# Comments for Planning Application 20/01514/FUL

Application Number: 20/01514/FUL

Address: Wilmington Hall Farm Broad Lane Wilmington Kent DA2 7AG

Proposal: Use of the site as a Construction Yard to store specialist foundation products together with installation of new modular office building, car parking provision and new sliding gate to existing entrance

00 Block Plan

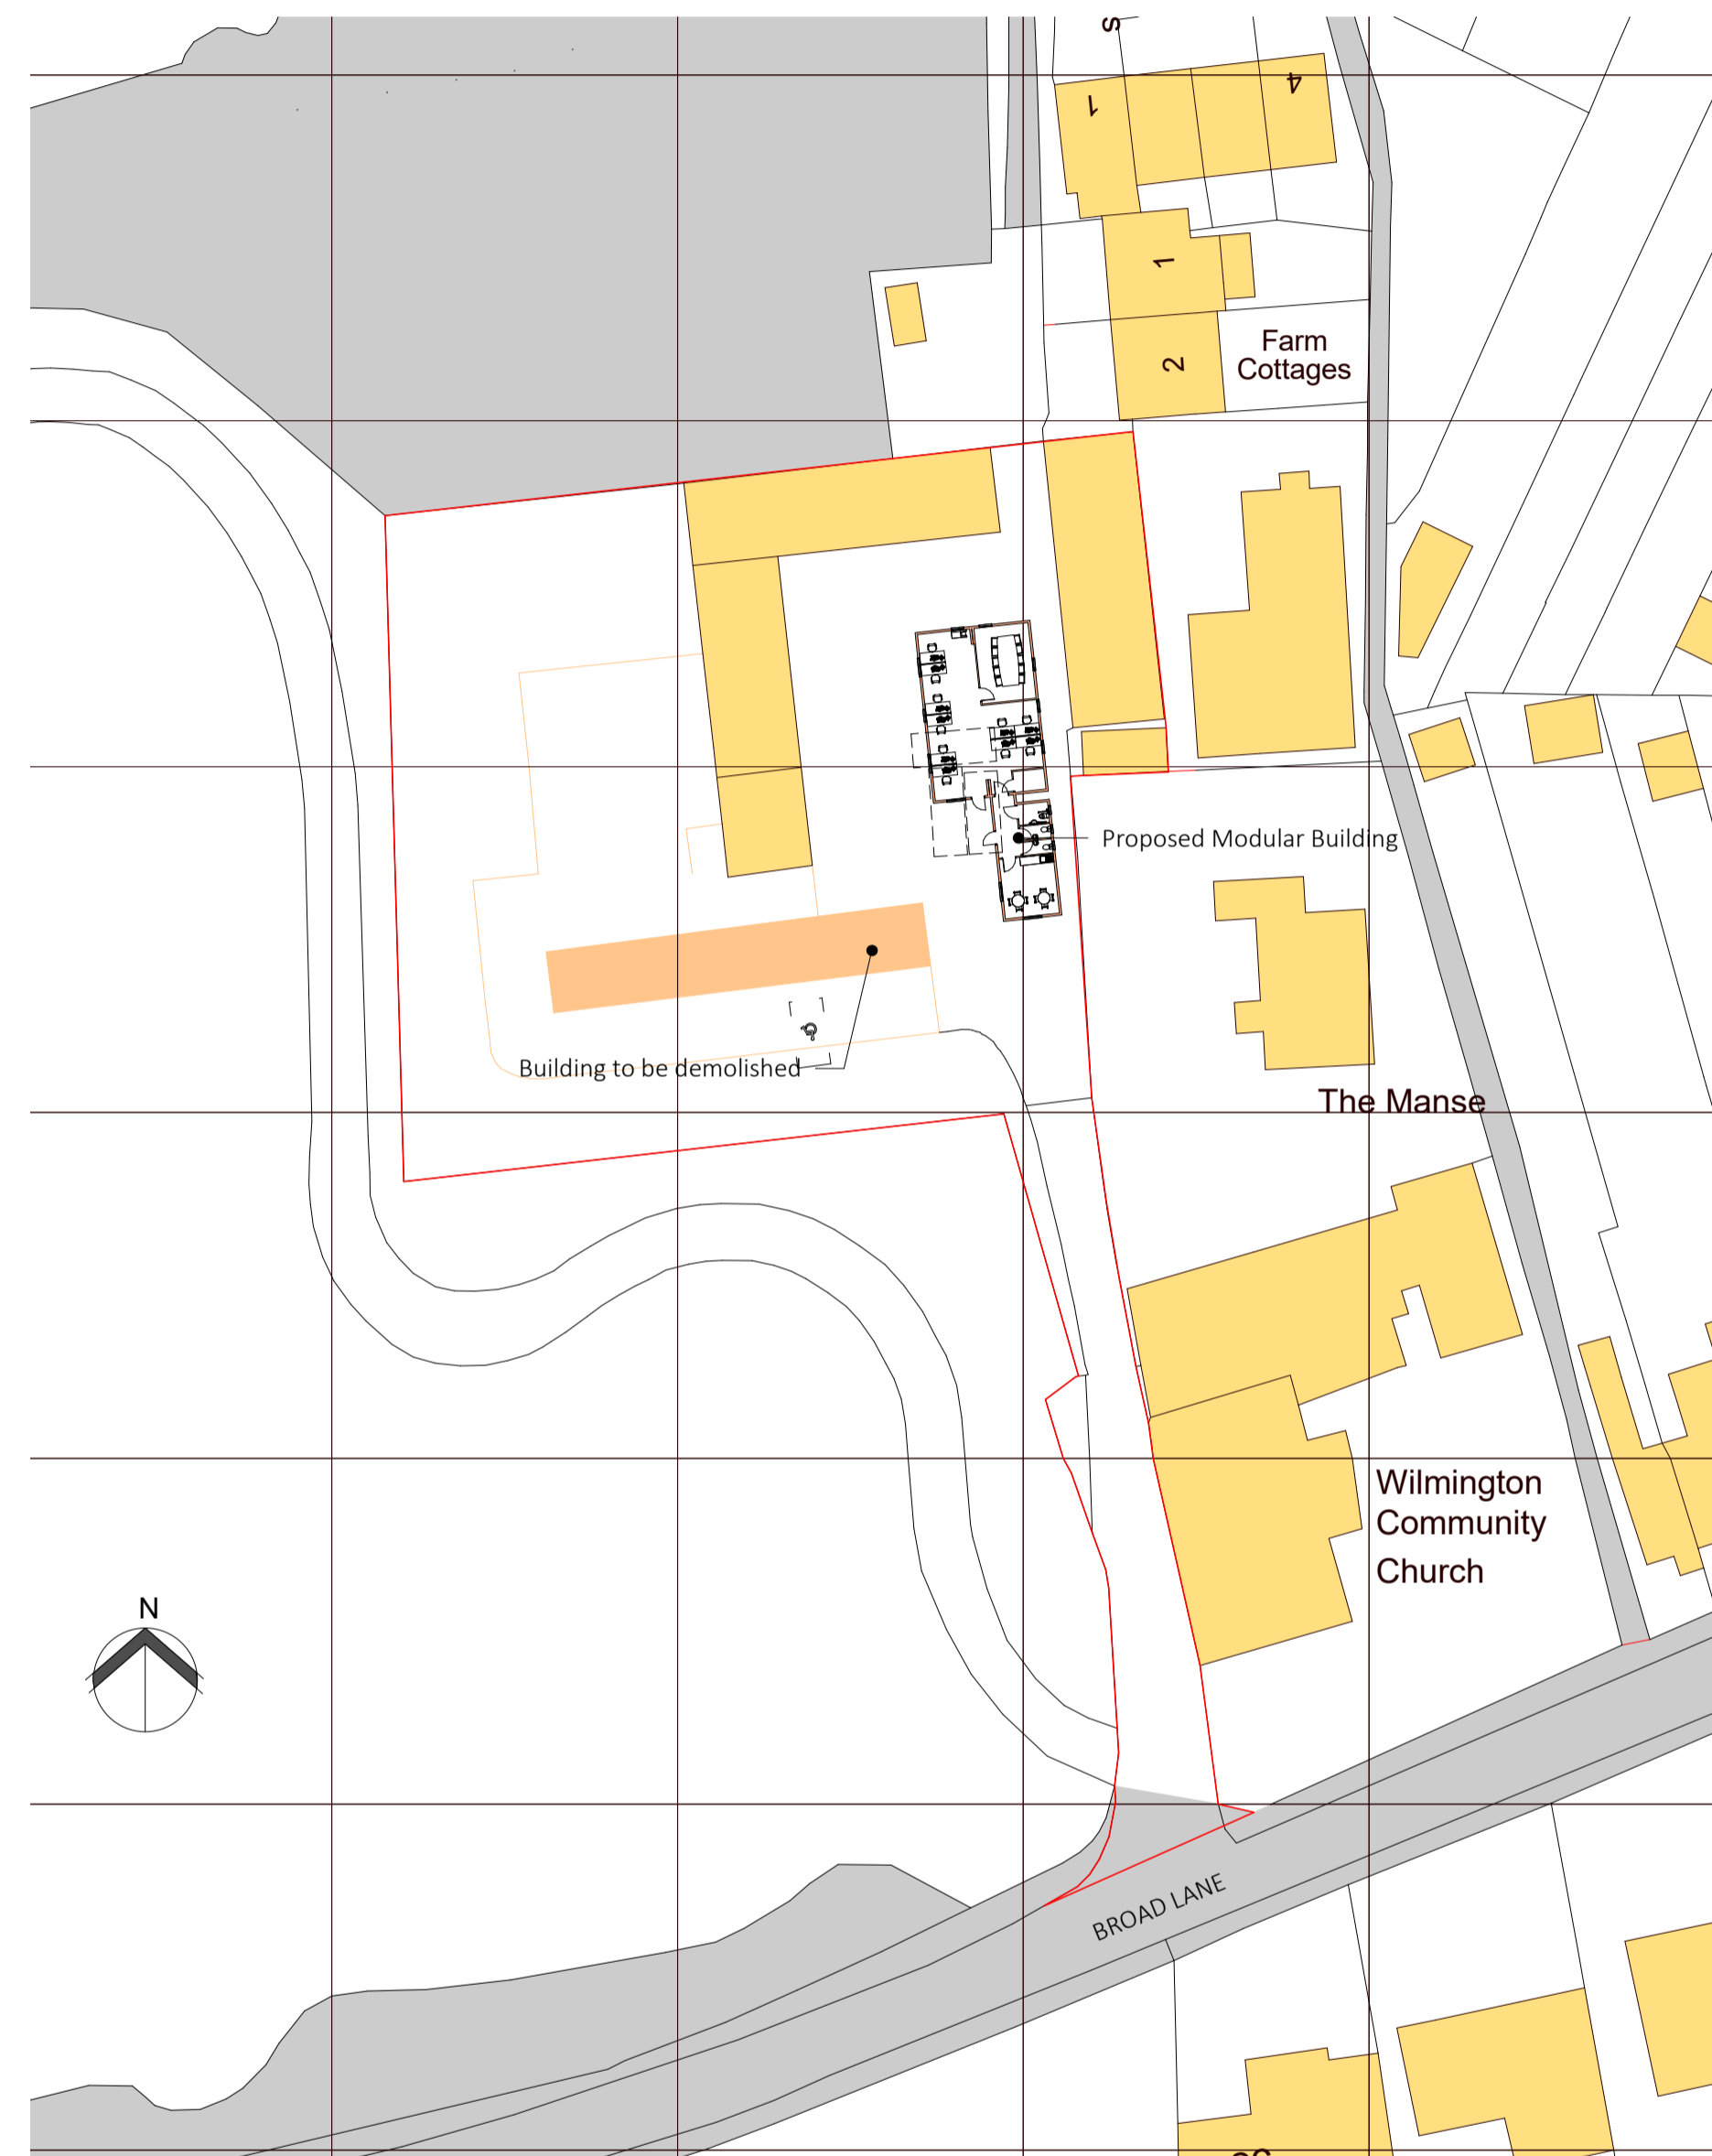
There are insufficient visibility splays on entrance and exit to the site, for the proposed HGV usage.

The site has an additional vehicle access point on Common Lane, fit for cars, this has not been identified on the plans. The road is an unmade road and will add to school congestion within the immediate area, where being used for business purposes, where 10 desks are required.
